CITY OF PORTLAND, MAINE
SITE PLAN REVIEW (ADDENDUM)
CONDITIONS OF APPROVAL

SITE ADDRESS/LOCATION: ^{121/123} ~~506~~ Woodlawn Ave, Portland, Me

**RESIDENTIAL DUPLEX
VICINITY OF 121-123 WOODLAWN AVE.
APPEAL OF REQUIREMENT FOR CURB AND SIDEWALK
MICHAEL L'HEUREUX, APPLICANT**

RE: 121-123 Woodlawn Ave Duplex

LOT 105

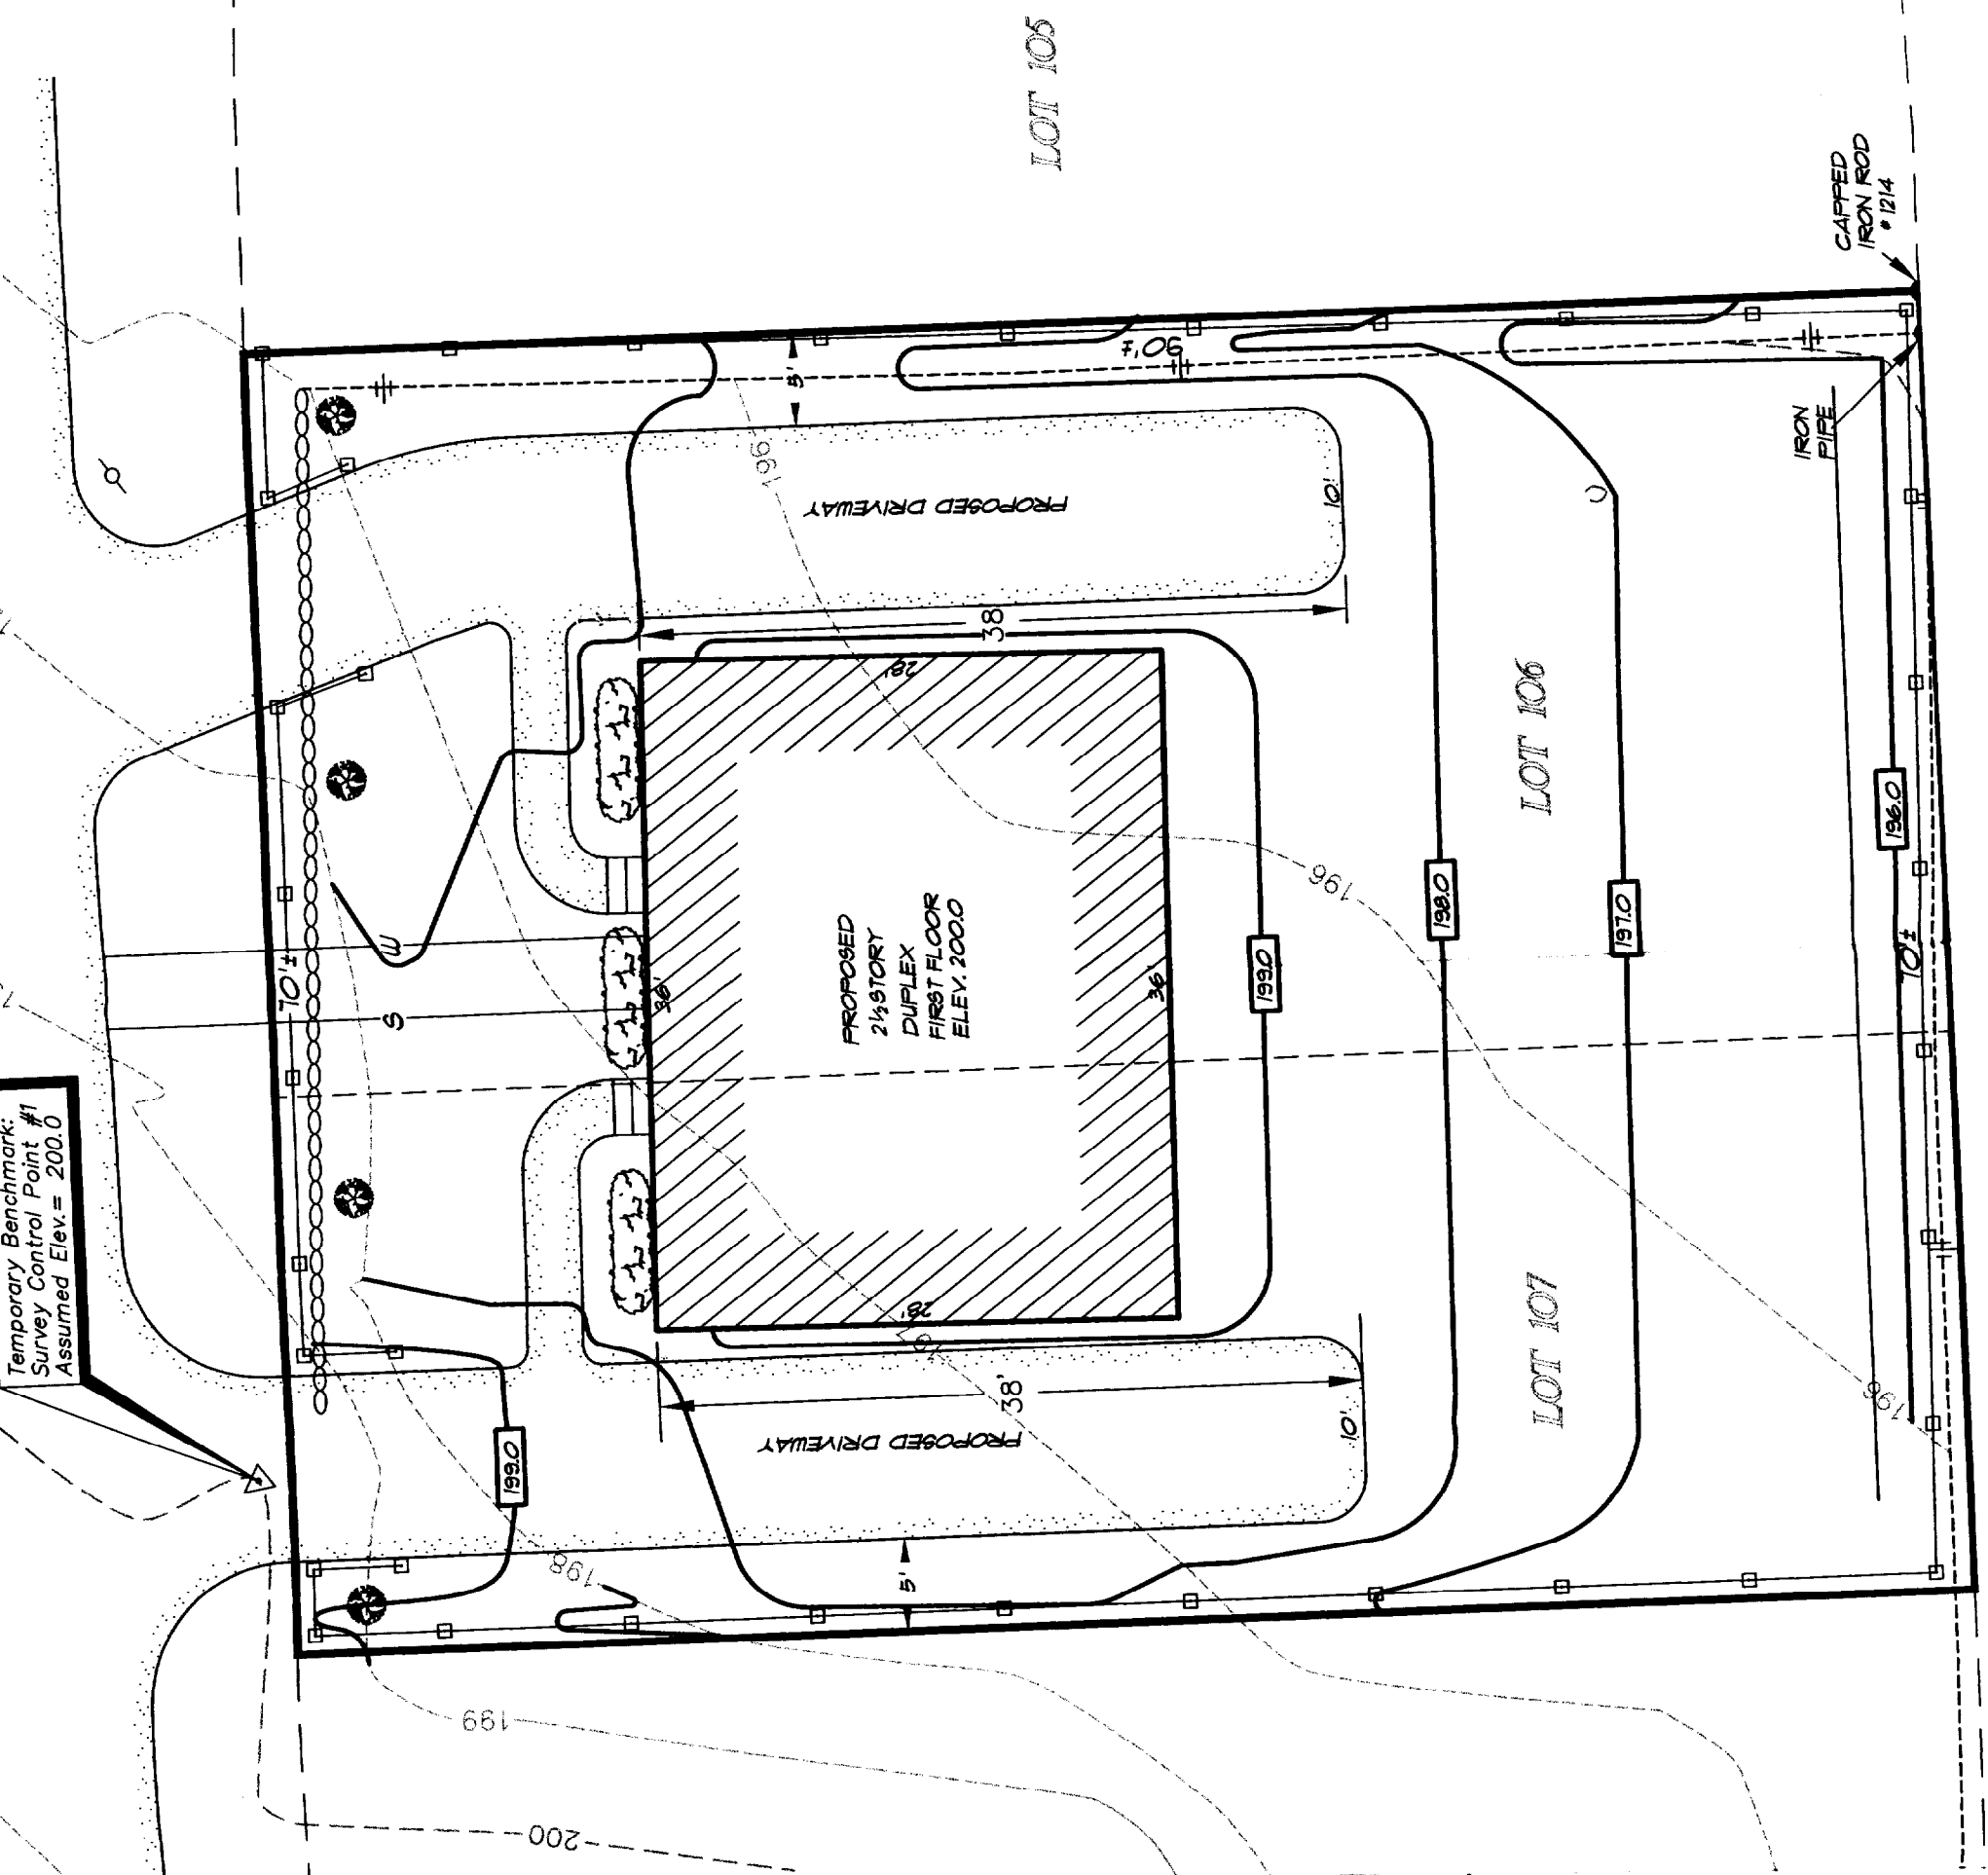
1. A revised drainage plan must be submitted paying close attention to drainage toward Lot 105 and drainage to the rear of your property.
2. You must show landscaping details.
3. You must show placement and type of erosion control measures.

FRONT ELEVATION
SCALE 1/4"=1'-0"

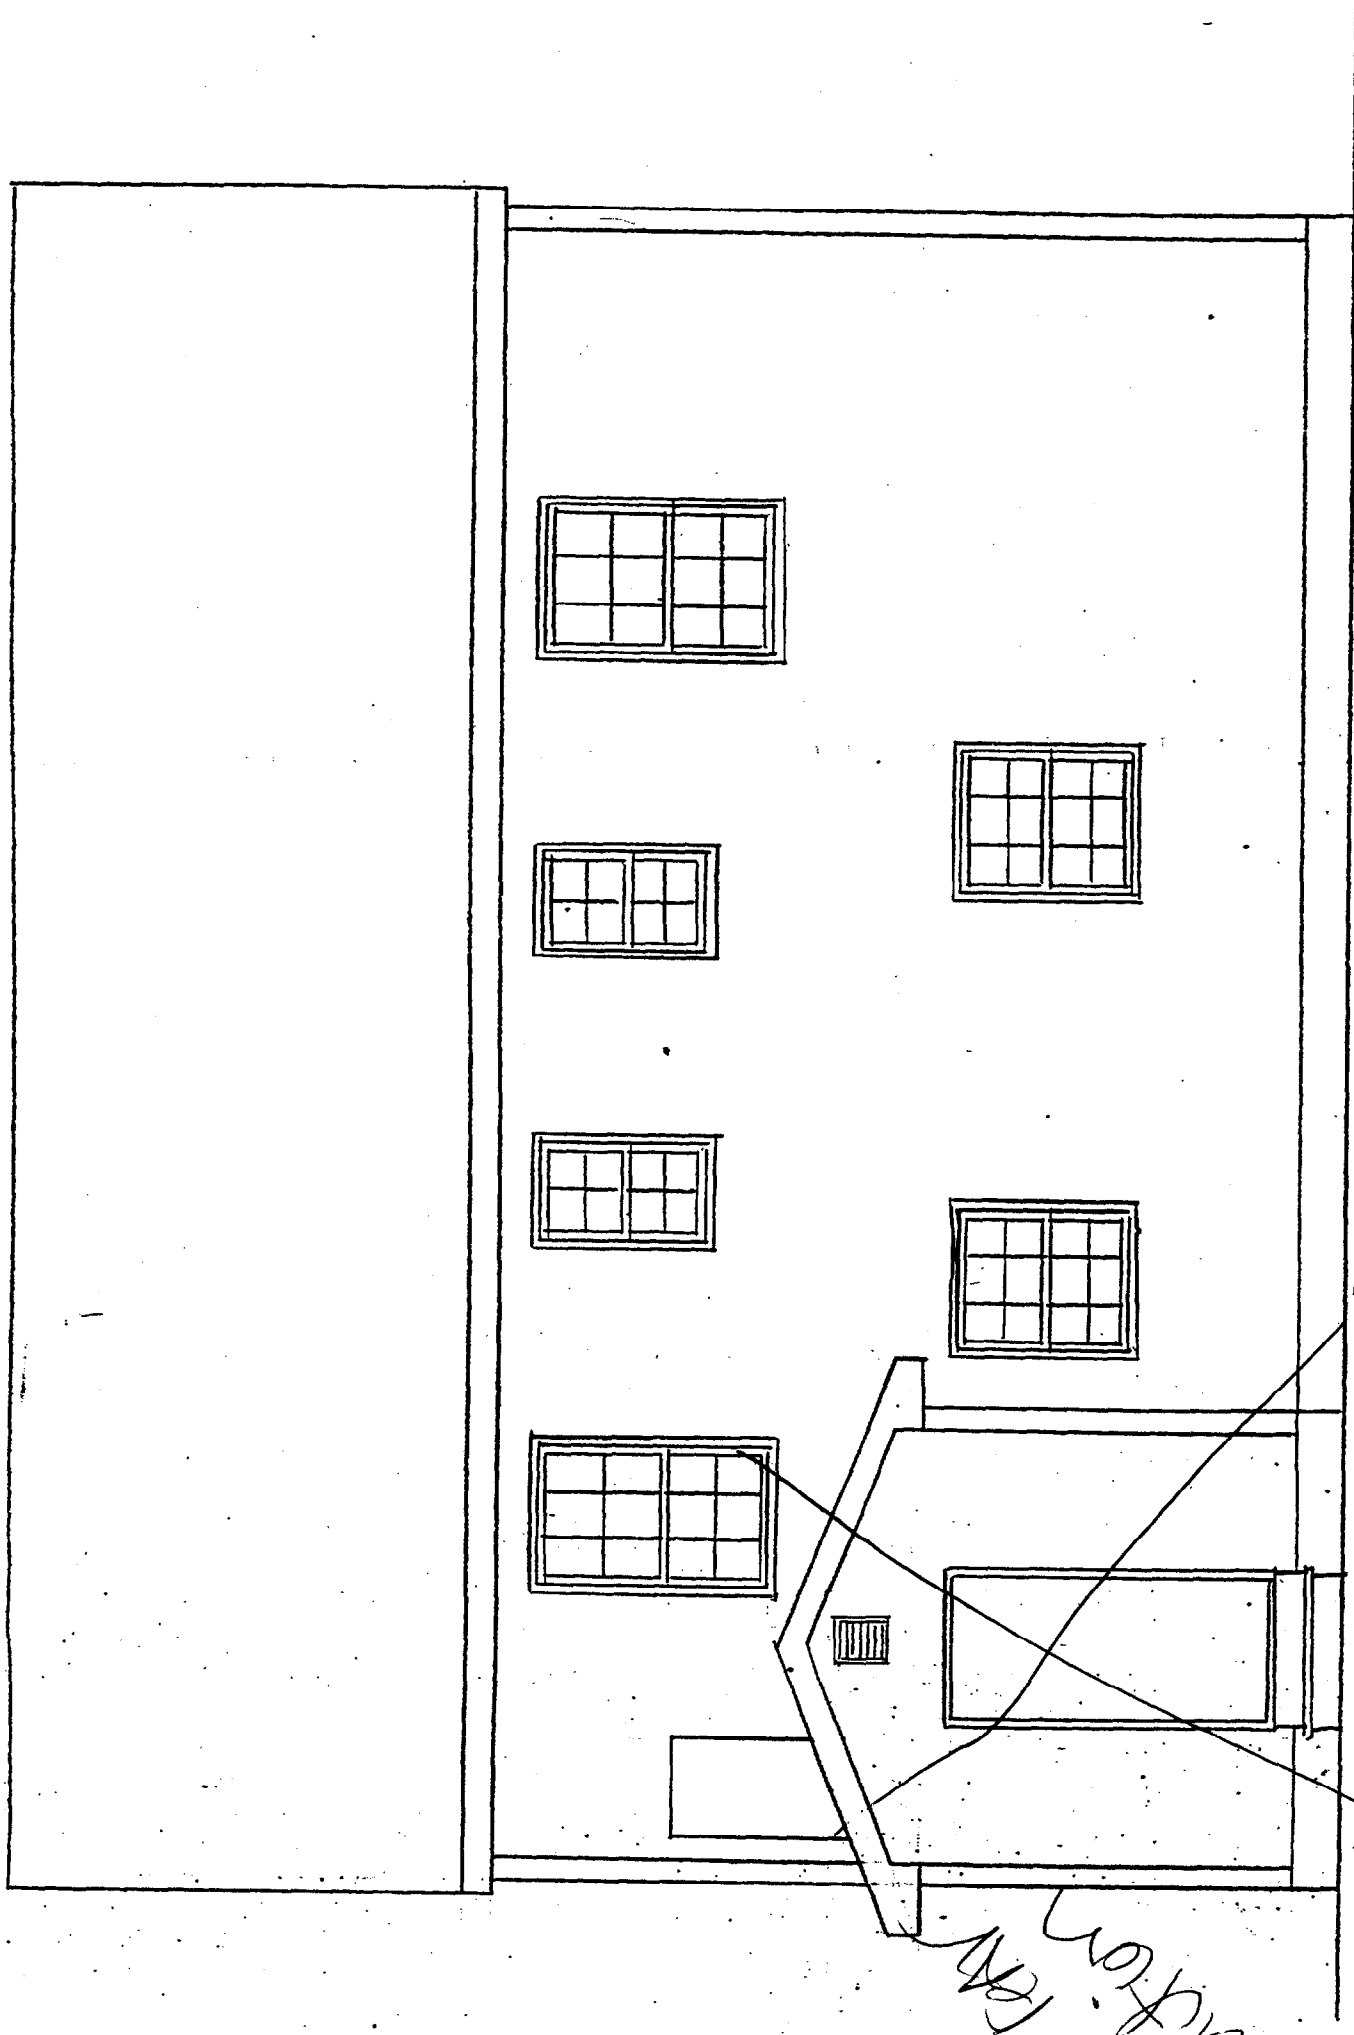
That prior to issuance of a building permit, the applicant will revise proposed elevation drawings to include a front entry porch or design feature over the doorway, to be reviewed and approved by the Planning Department. (Examples of similar features on duplexes recently approved duplexes are attached.)
